From: Georgios Chrysanthakopoulos <georgechrysanthakopoulos@live.com>
Sent: Sunday, May 29, 2016 8:42 PM
To: Jeff Watson
Cc: gyllingconsulting@fairpoint.net; tyrcramer@romein.com
Subject: FW: Mitchell (SP-16-00001) short plat notice dated May 18, 2016
Attachments: IMG_20160529_162505618.jpg

Hi Jeff, this is regarding the Mitchell Short Plat application. I am one of the owners in Hidden Valley.

**MITCHELL SHORT PLAT
PART OF SECTION 31, T. 20 N., R. 17 E., W.M.
KITITIAS COUNTY, WASHINGTON**

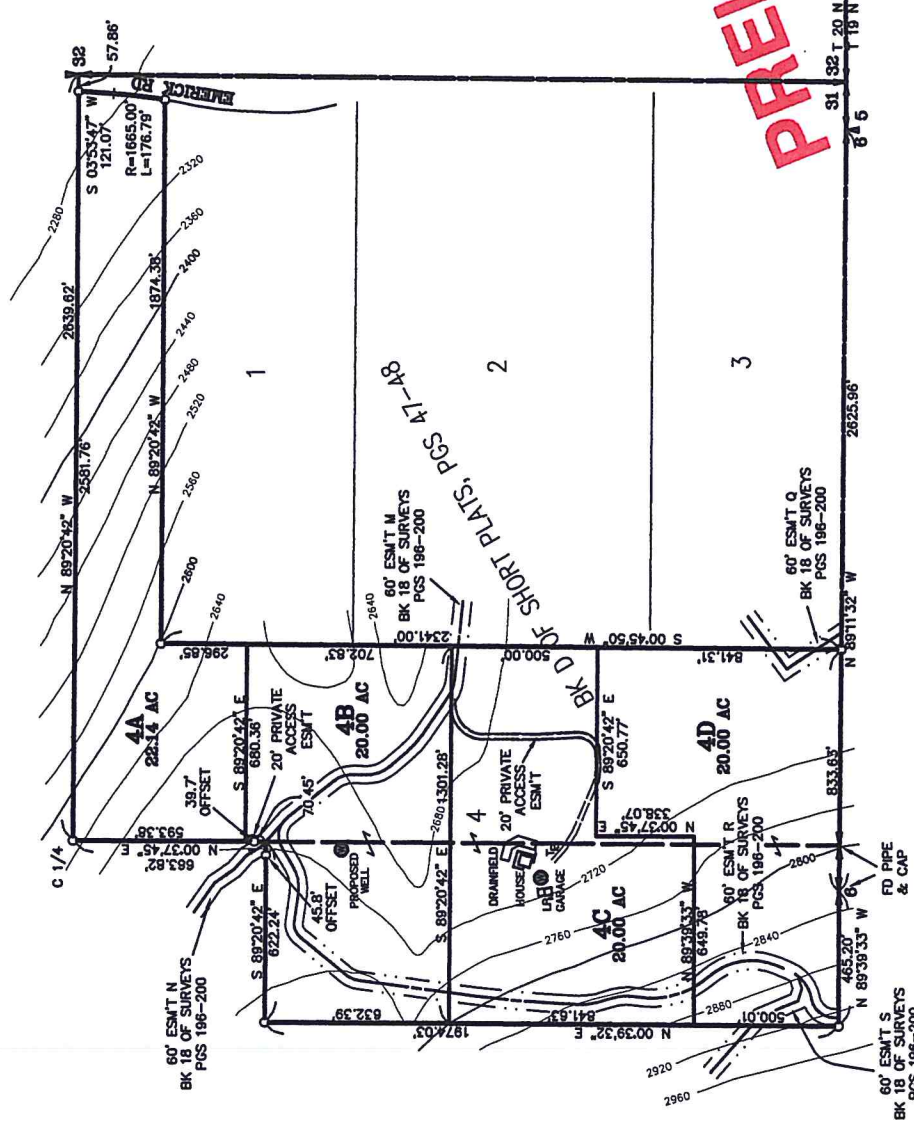
Hi Jeff, please also include the following in the public record / comments, associated with the short plat application. I took pictures of the seasonal wetland / pond, in one of the sections proposed in the short plat. Myself and other owners feel this location needs to be protected and it currently does not appear to be listed as a sensitive area / wetland, in the short plat application.

You can clearly see the seasonal pond, and it appears it has recently dried for the season. Last year, when we hiked around there in April, it was full of water.

One of the lots in the short plat appears to violate the following section of the Kittitas county code, title 17, forest and range:

See section 050, part 2, the length to width ratio.

1. No parcel created after the adoption of the ordinance codified in this chapter shall have a length-width dimension less than five hundred (500) feet unless the parcel is approved under provisions established in Section 17.56.040 2 and 3.
2. No platted parcel shall have dimensions in excess of a 4:1 length by width ratio. (Ord. 2013-001, 2013; Ord. 2007-22, 2007; Ord. 92-6 (part), 1992; Res. 83-10, 1983)
